Online Comment

Application H05-0612-15
Location HERON COTTAGE CAMPING AND CARAVANNING FROSTLEY GATE
HOLBEACH PE12 8SR
Proposal Proposed replacement of 19 touring/camping pitches to 16 static caravan
pitches - approved under H05-0862-13. Modification of wording to
Condition 5

DRAWING Site Layout

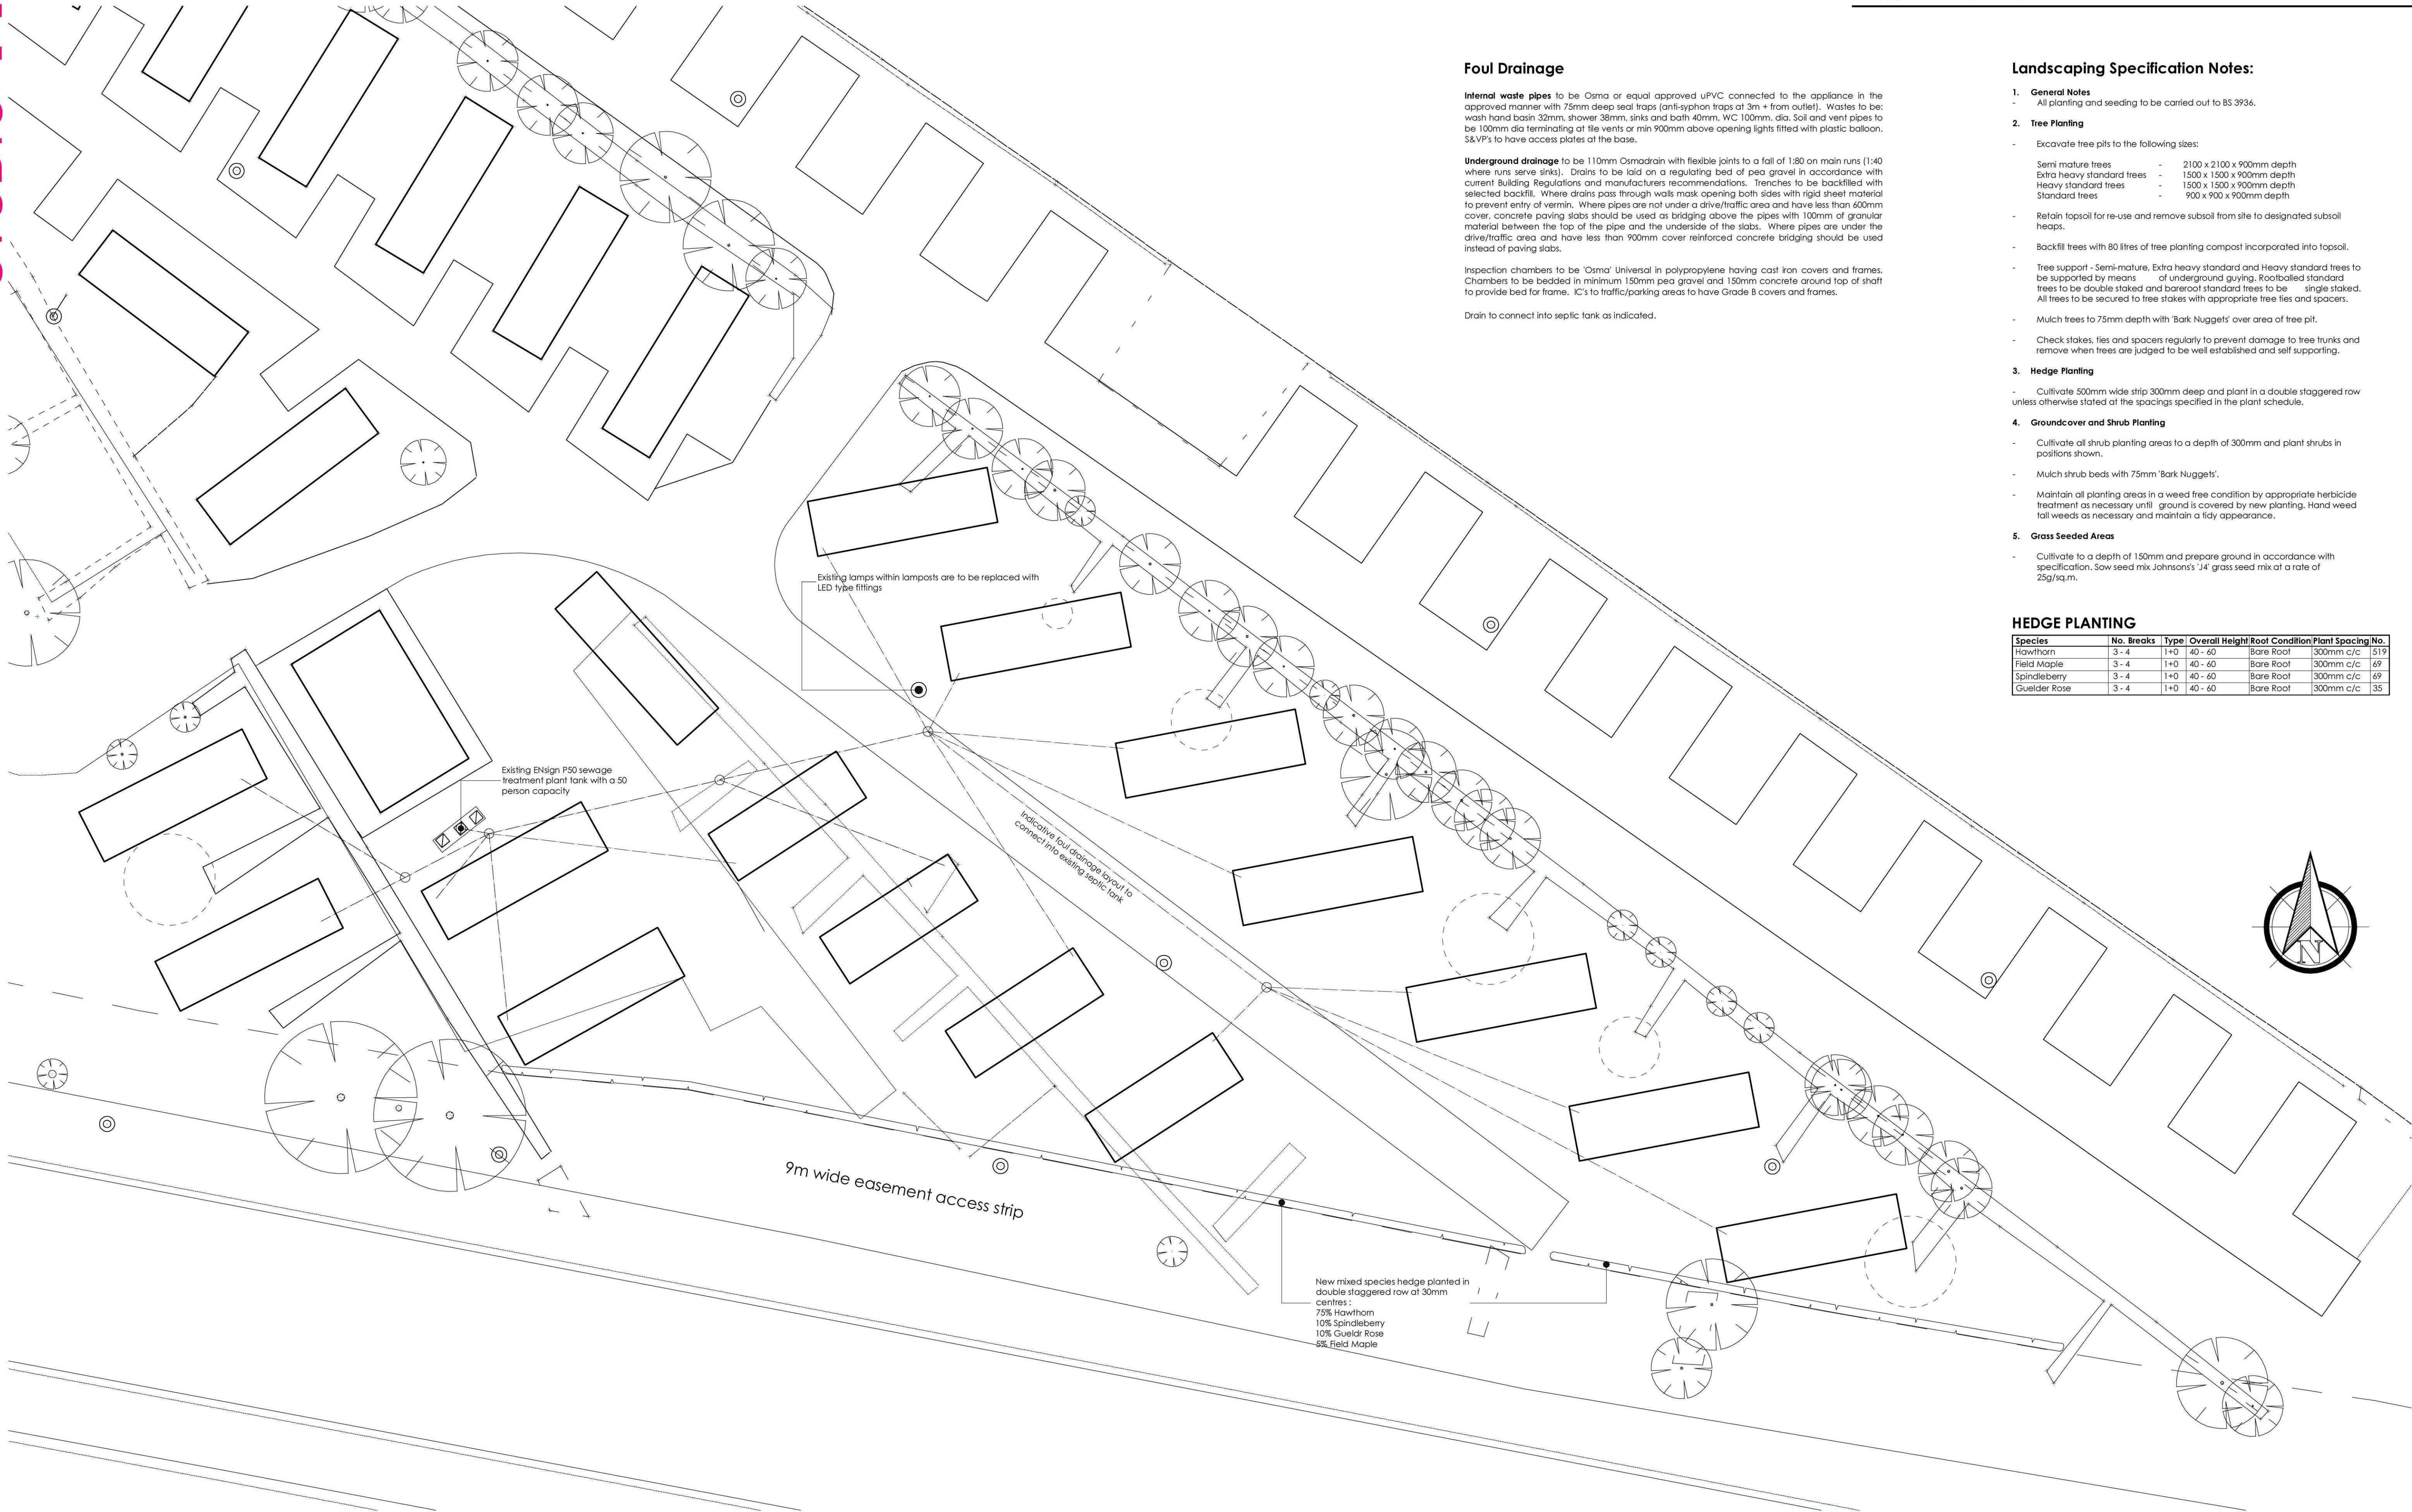
I have no objections in principle to this application. The caravans need to comply with site
licence regulations and be 6m apart.
